30 June 2025

**Re: State Significant Development Application Number SSD-78520463
54-56 Anderson Street, Chatswood**

Figure 2: Pillars and doors opening on through site link

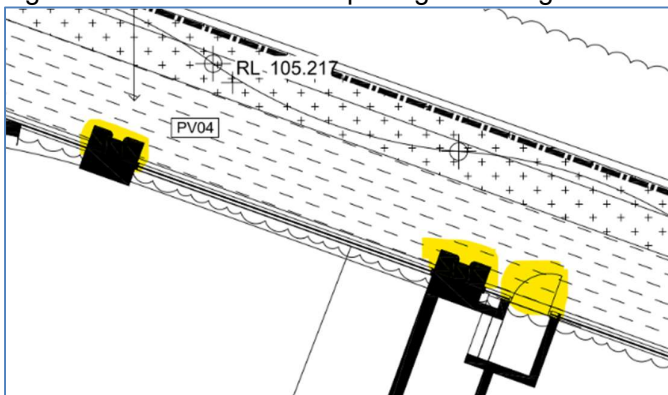
Council requests the pillars located within the through-site link to be further set back to improve accessibility. The doors exiting to the pathway should open inwards only. This is easily achievable through a redesign and conditions of consent.
